From: [Christy Garcia](#)
To: [Jeremy Johnston](#)
Subject: RE: Request for Final Plat Review LPF-19-00003 Palomino Fields Div 2
Date: Tuesday, March 26, 2019 11:09:44 AM

We have received a final plat submittal for the Palomino Fields Div 2 Plat (LPF-19-00003). This was given preliminary approval on November 18, 2008 and was processed under file number LP-07-00031. All final plat documents can be found on the t-drive: [LPF-19-00003 Palomino Fields Div 2](#) , including a copy of the approval resolution 2008-160. Please let me know if there is documentation you need to review that you are unable to find.

Surveyed by LMH Scale 1" = 300'
Drawn by Tml/FCS Sheet 1 of 5
Checked by FCS Project No. 18146

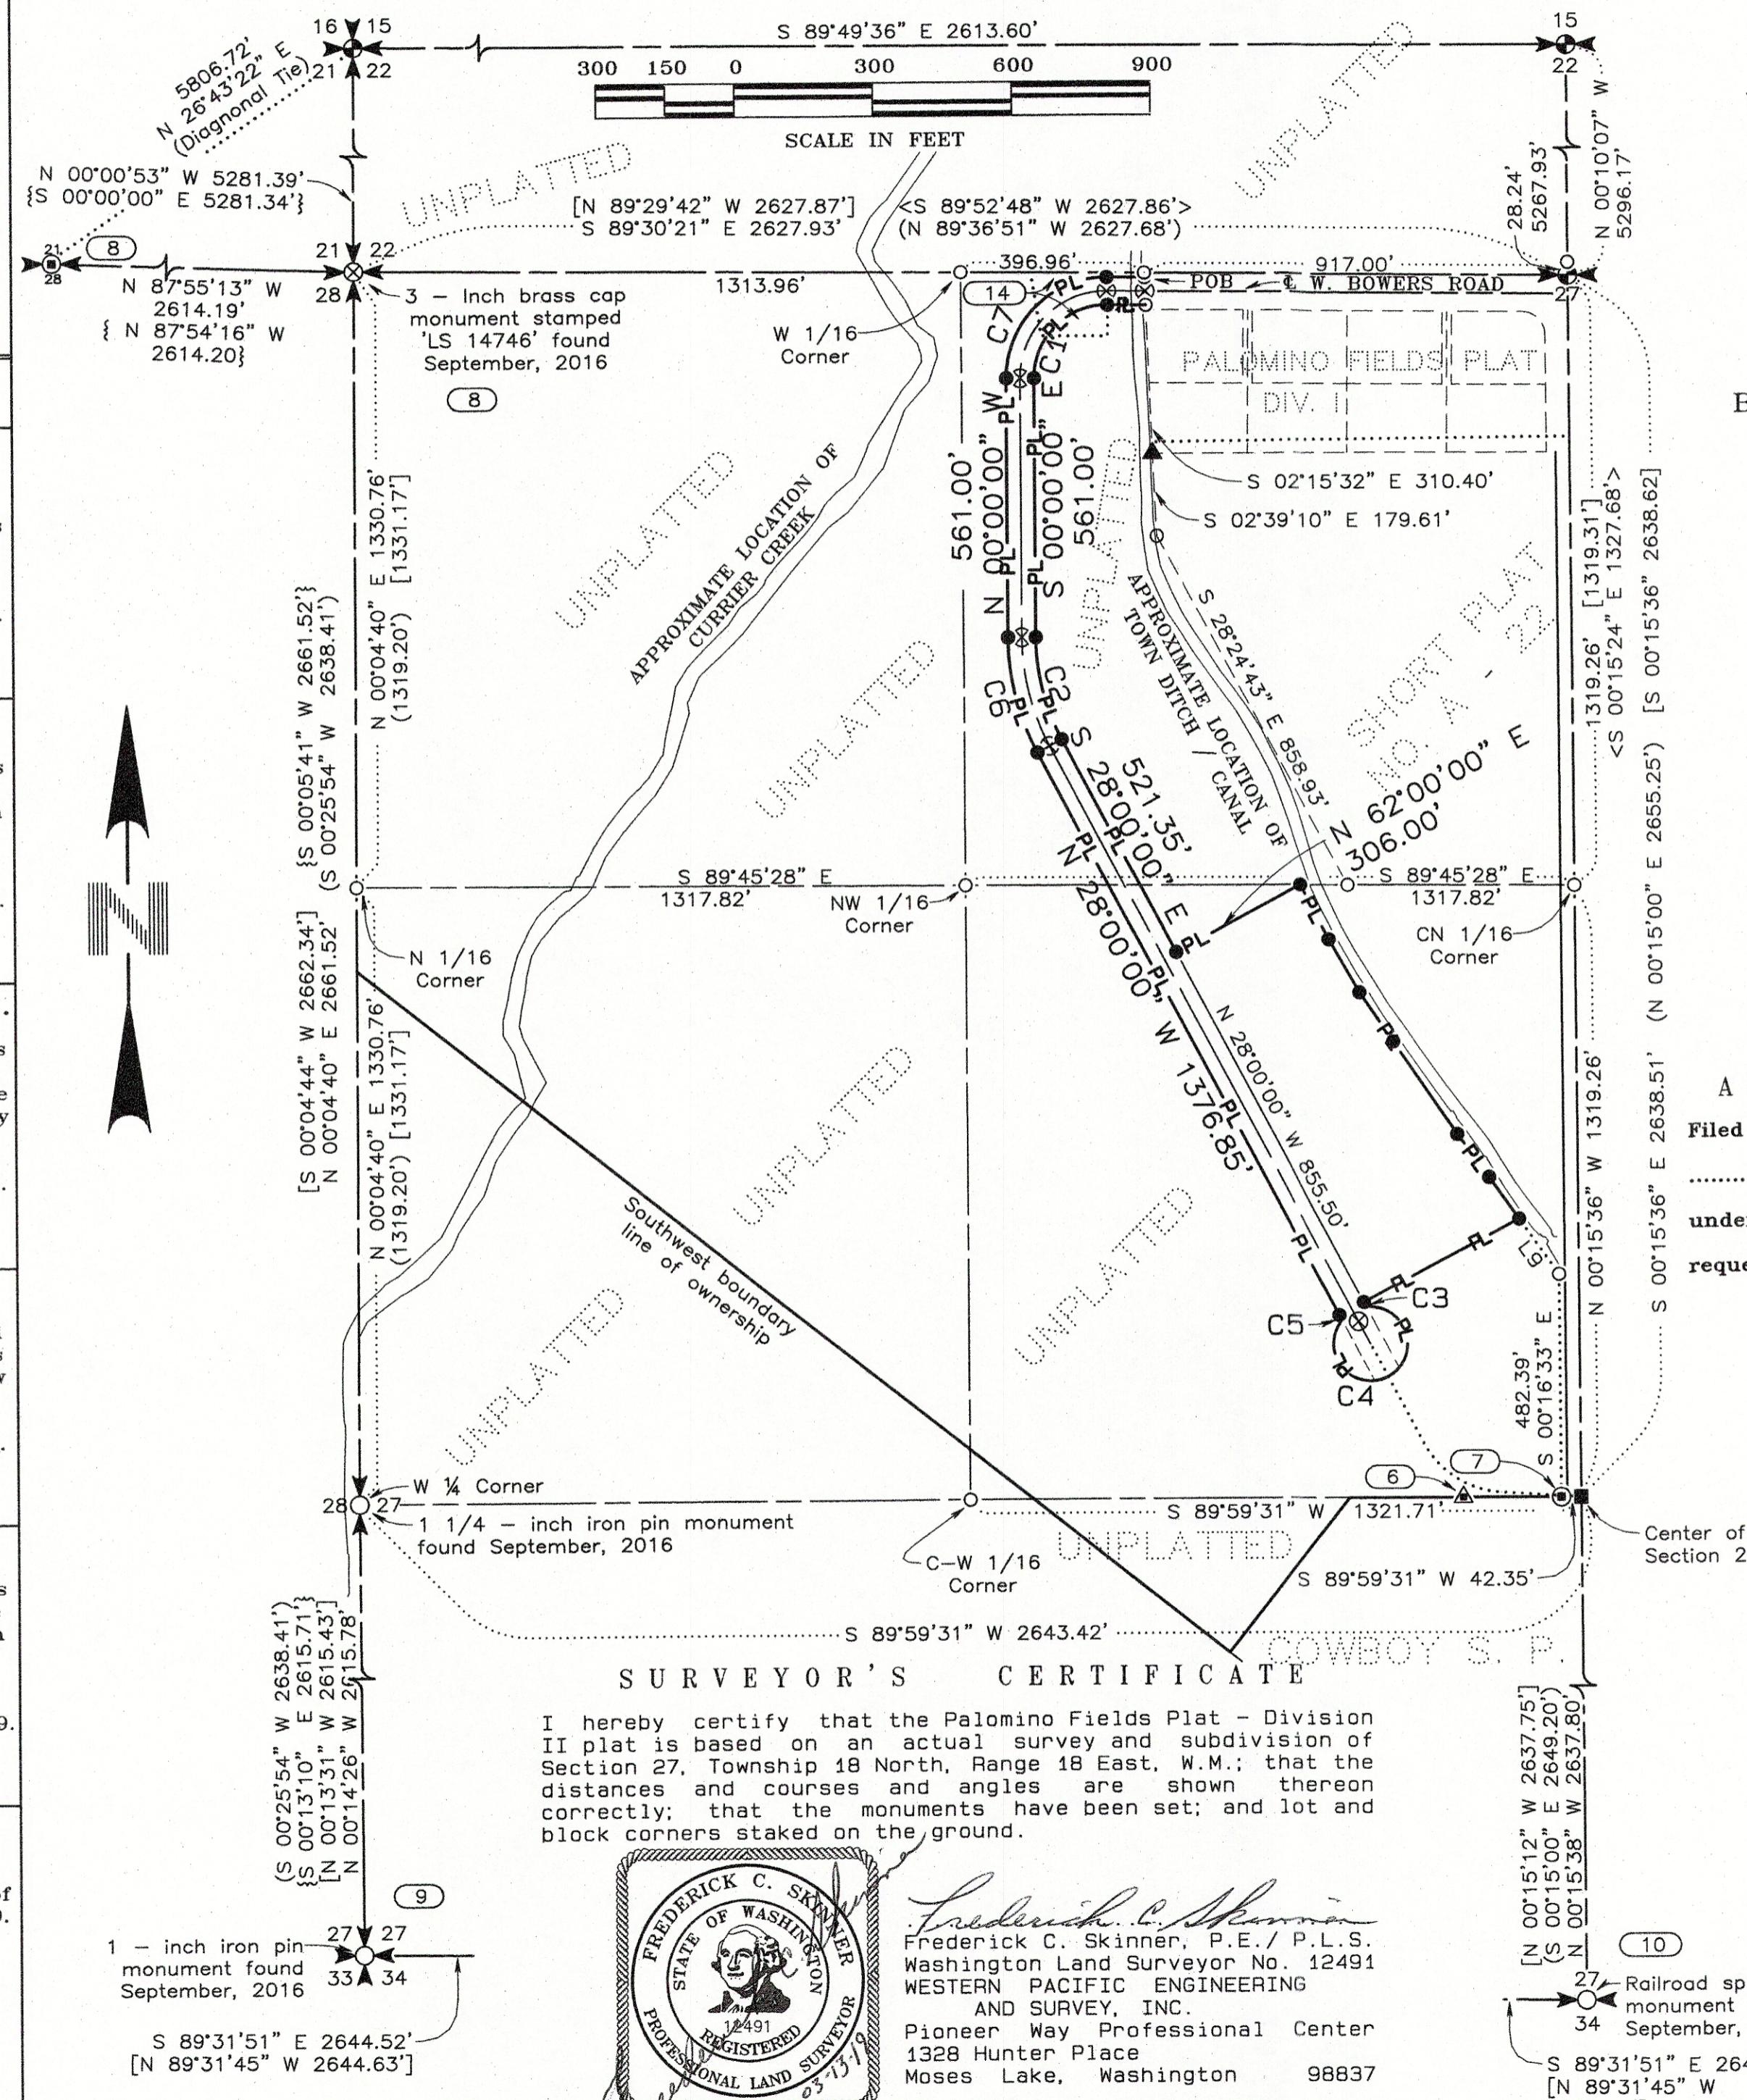
In reviewing the information on the preliminary survey documents, I noticed that between the Treasurer's and the Assessor's signature box a couple of errors. The Treasurer's box only lists a single incorrect parcel number of 471033, the correct number is 491033. Parcel number 471033 was retired during the creation of Palomino Fields Division 1 to create eight new parcel numbers. This is also incorrectly listed in the Assessor's signature box.

There are also two additional parcels involved (11801 & 11802) and they are listed correctly in the Assessor's signature box, but not listed in the Treasurers.
